Hampton Cottage
7 Church Street
Littlehampton
West Sussex
BN17 5EL

Re: LU/13/15/PL Planning Application

SOUTH ELEVATION PLOTS 1 TO 5 PROPOSED

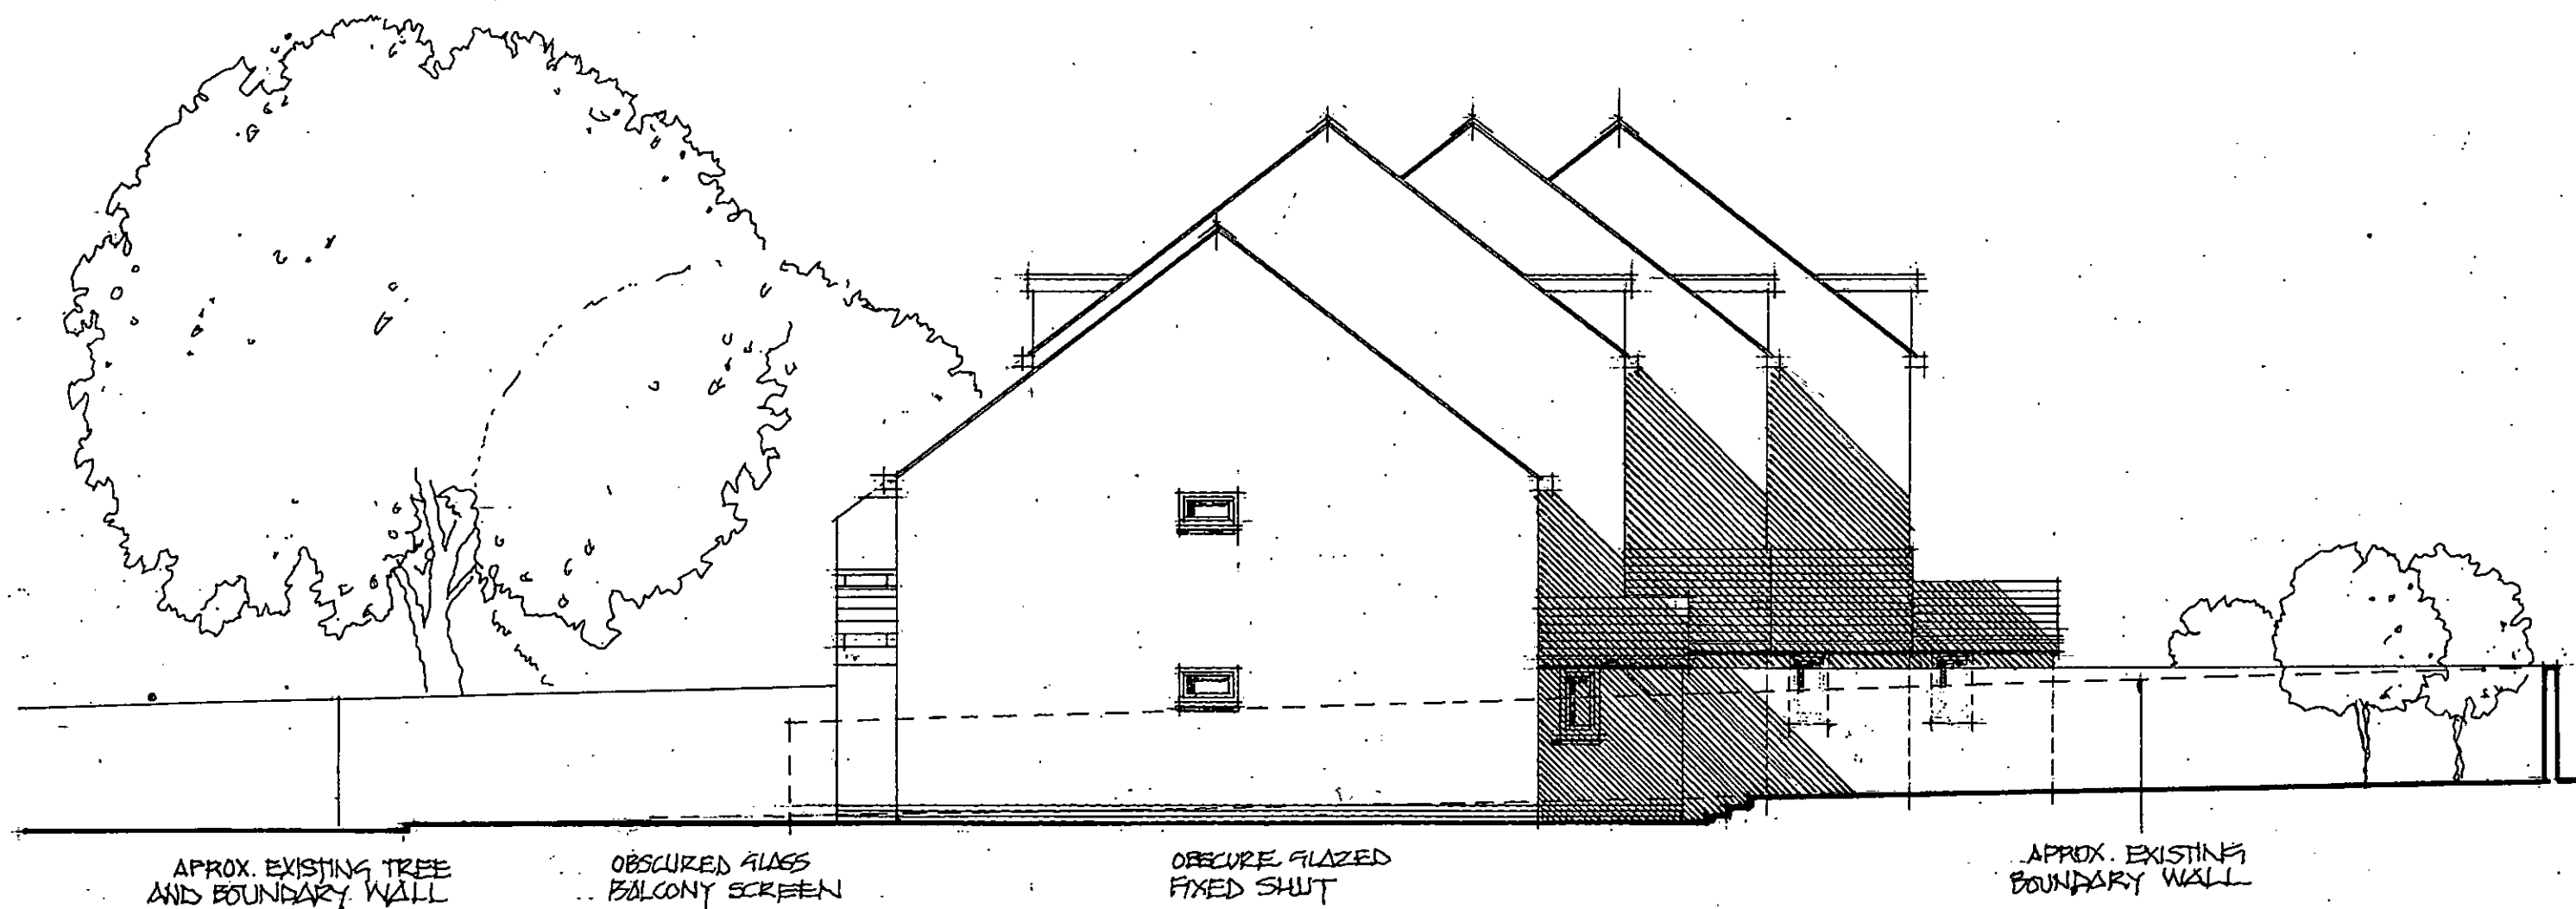
- 2) If there is an addition of balconies to all these houses this will bring the presence of this new street audibly and visibly to those living close to it in this Conservation Area which considering its location in this town has always been very peaceful and greatly valued for this by its residents. If parties are held in the summer the noise issue from these balconies could cause problems (there was a music ban imposed on the previous tenants of the site, as sound echos all around the area). Also, if they If they remove the brick wall currently behind 7,9, and 11 Church Street, those houses will be overlooked.
